Attachment A

1. Biodiversity

The Department considers that the EA does not adequately address the relationship between the Haerses Road and Old Northern Road sites, and the potential traffic impacts of the proposed modification. Your attention is drawn to condition 3.30 of the development consent for the Old Northern Road Quarry (DA 250-09-01), which states that the combined daily truck movements at that site shall not exceed 180. This includes up to 28 inbound trucks from the Haerses Road Quarry. The proposed modification would allow 100 percent of outbound trucks from the Haerses Road site to travel direct to market.

Figure 8: Location of noise receivers

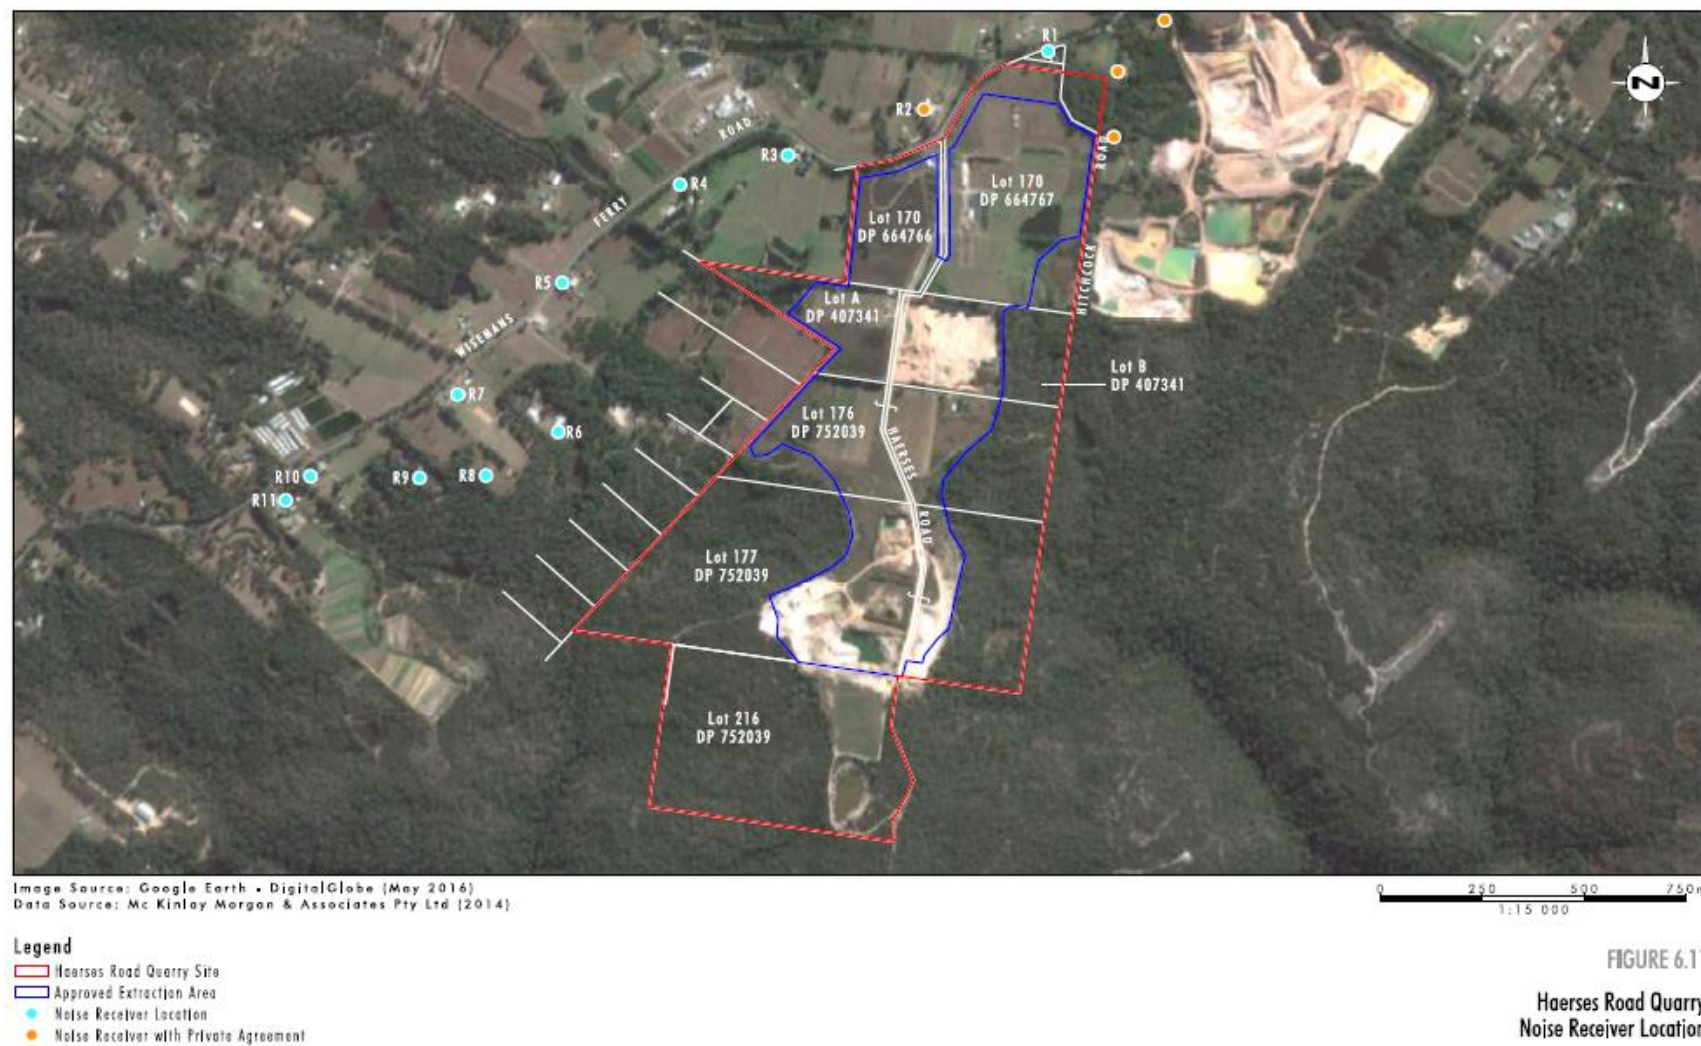
Table 6.14 of the Noise Impact Assessment (NIA) indicates that the predicted L_{Aeq} (15 minute) daytime noise level for Receiver 1 during early extraction of Cell 4 is 41 dB(A). This result appears incongruous when compared with the other predictions for Receiver 1, and this apparent exceedance is not discussed elsewhere within the NIA. DPE requests further information or clarification on this matter, in addition to the other issues raised by the EPA in its submission.
